From: Simon Davis
Sent: 21 January 2019 12:44
To: 'Adrian Hoy' [REDACTED]
Subject: RE: BR/214/18/PL

Drg No: **RNHB.PLAN 1**

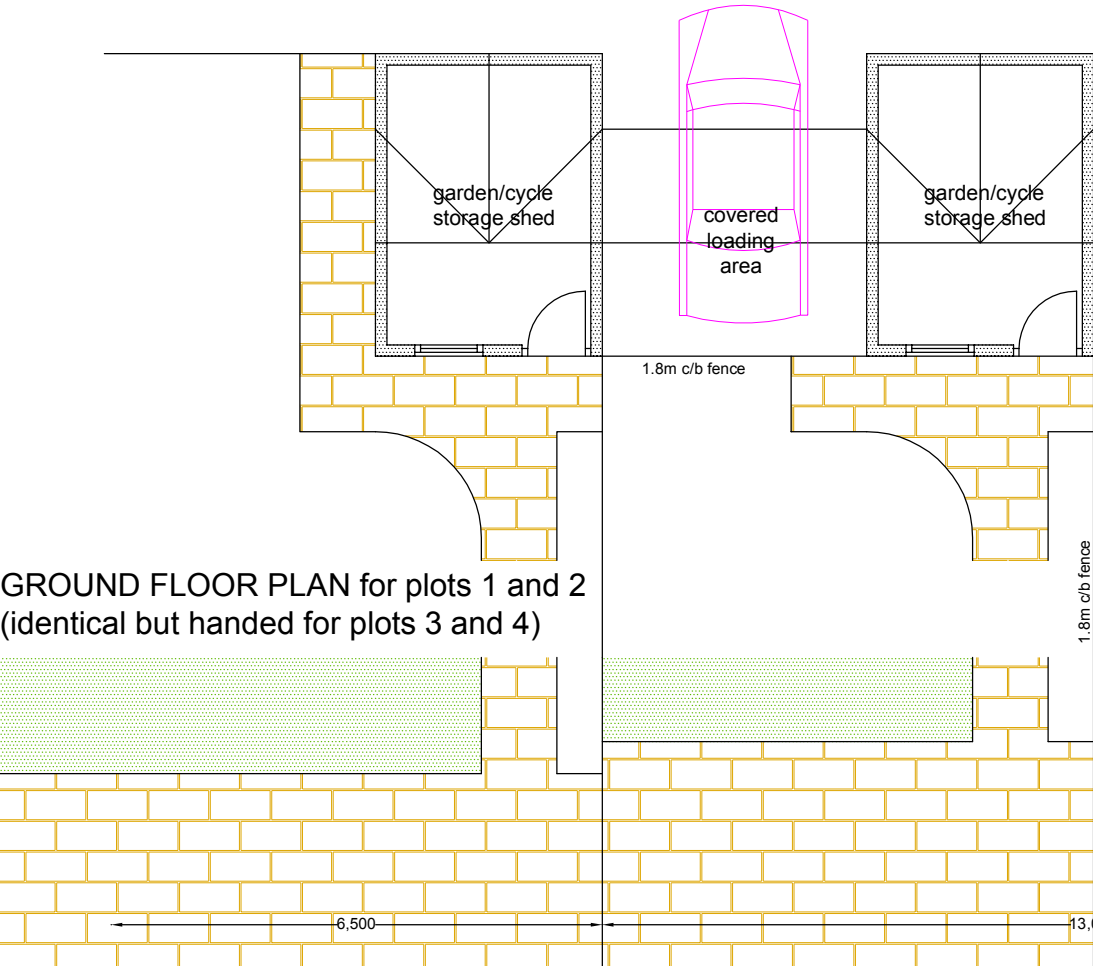
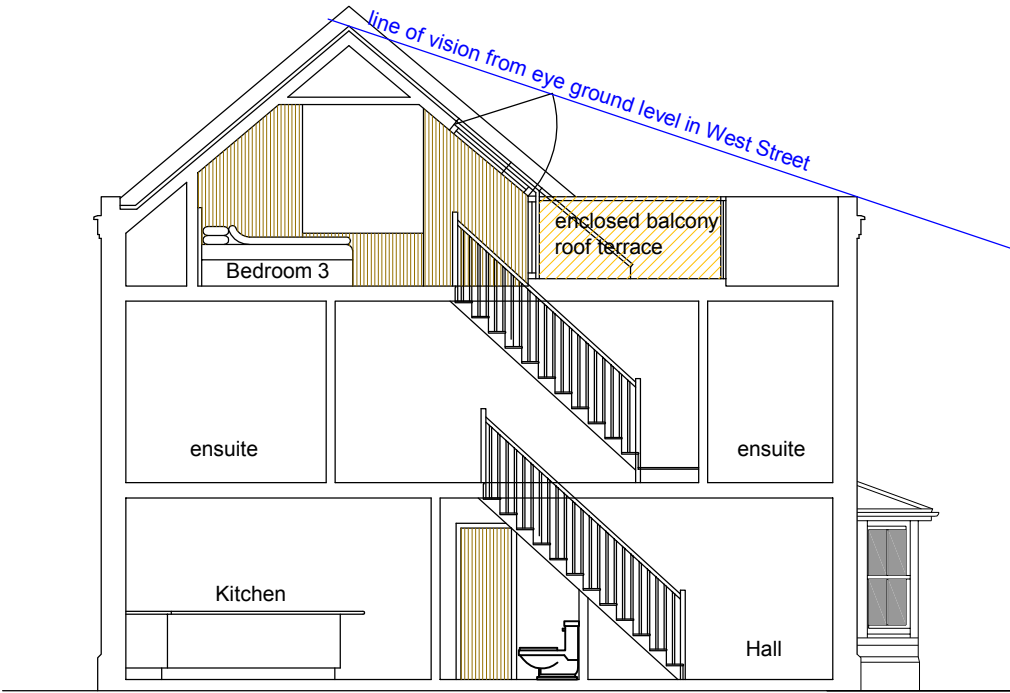
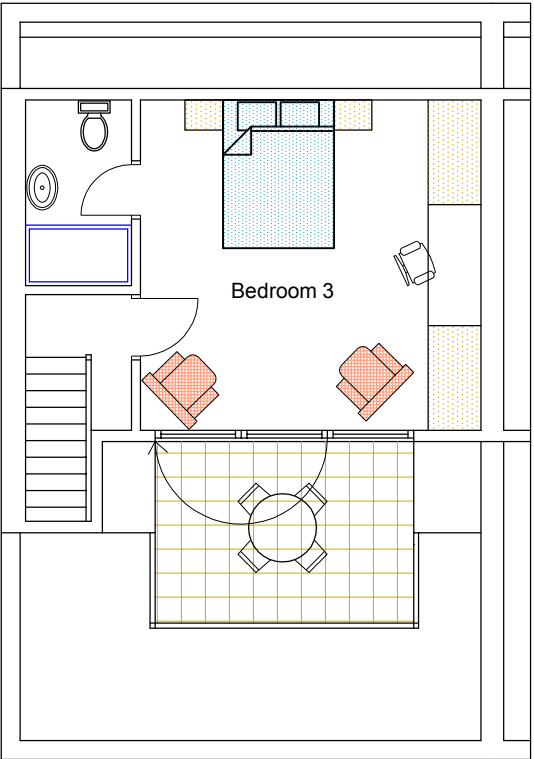
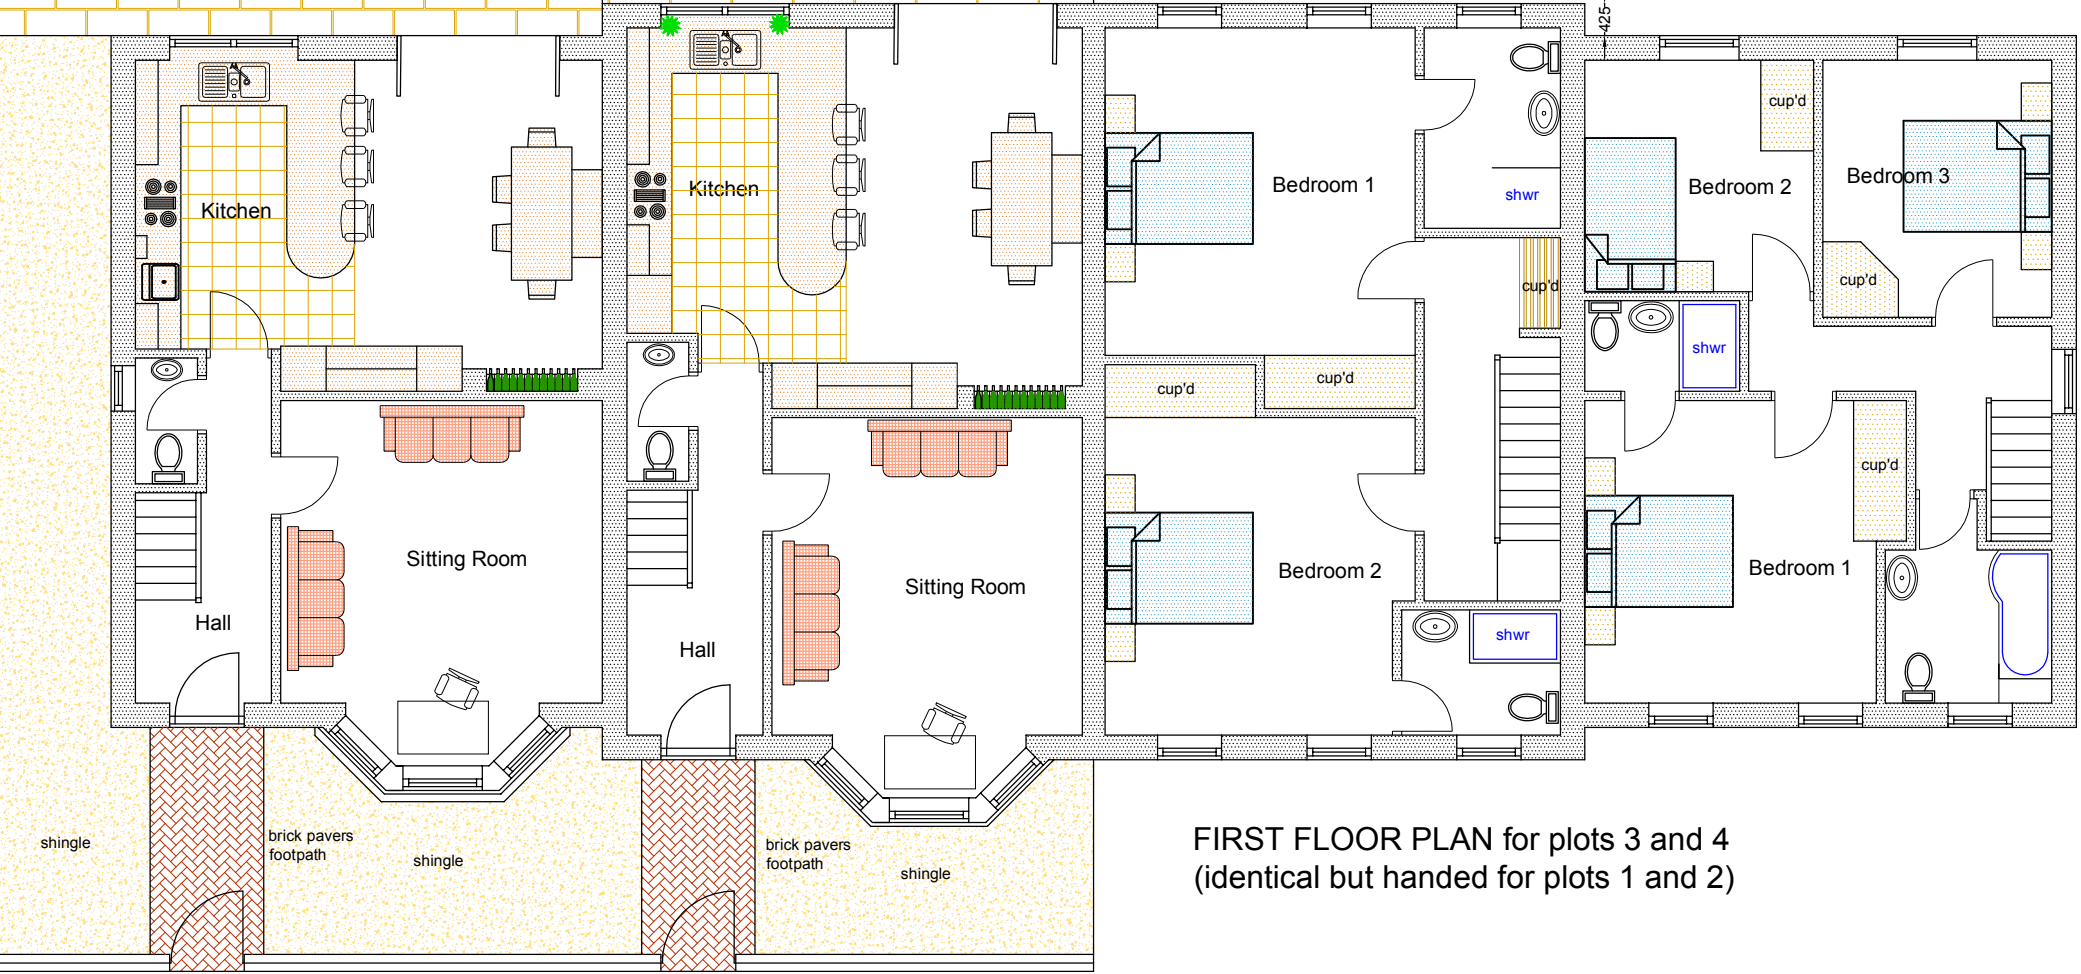
- reduction in the number of dwellings from 4 to 3 with resulting smaller built form
- say if the southernmost dwelling were removed then this part of the site could become curtilage to the new southernmost dwelling – this would mean that this part of the site remained open allowing views through to the hotel
- two storey terraced built form with pitched roofs

Drg No: **RNHB.PLAN 2**

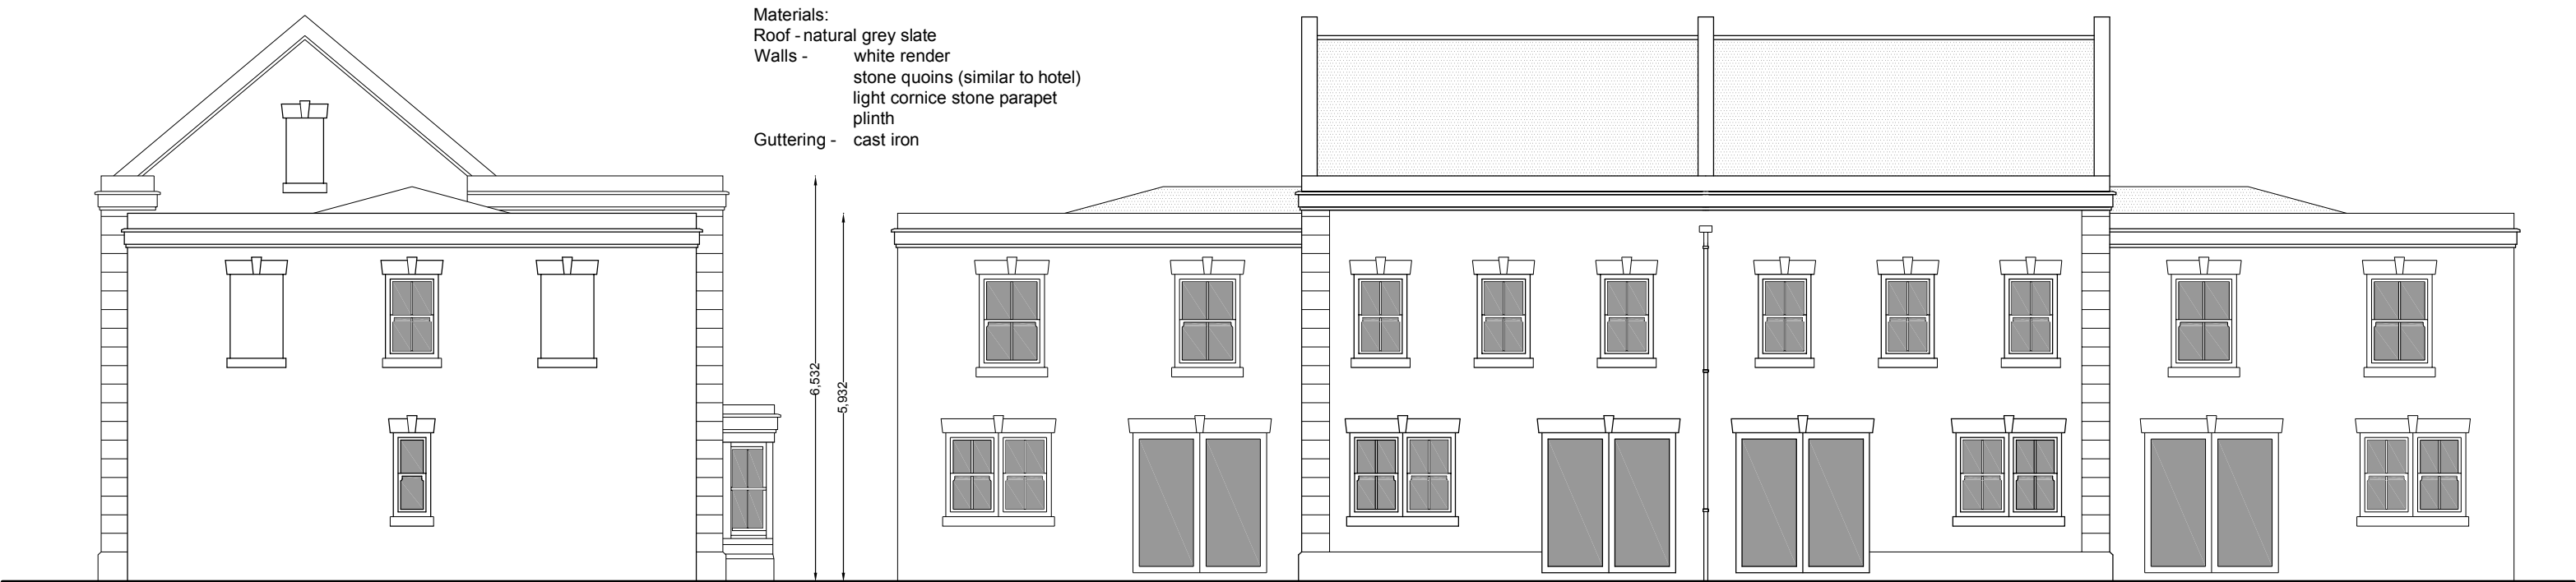
We would welcome the omission of the roof terraces but the objection would still remain to the current proposal and as such, would need to be refused.

The roof terrace can be omitted, thus resolving one aspect of his concerns.
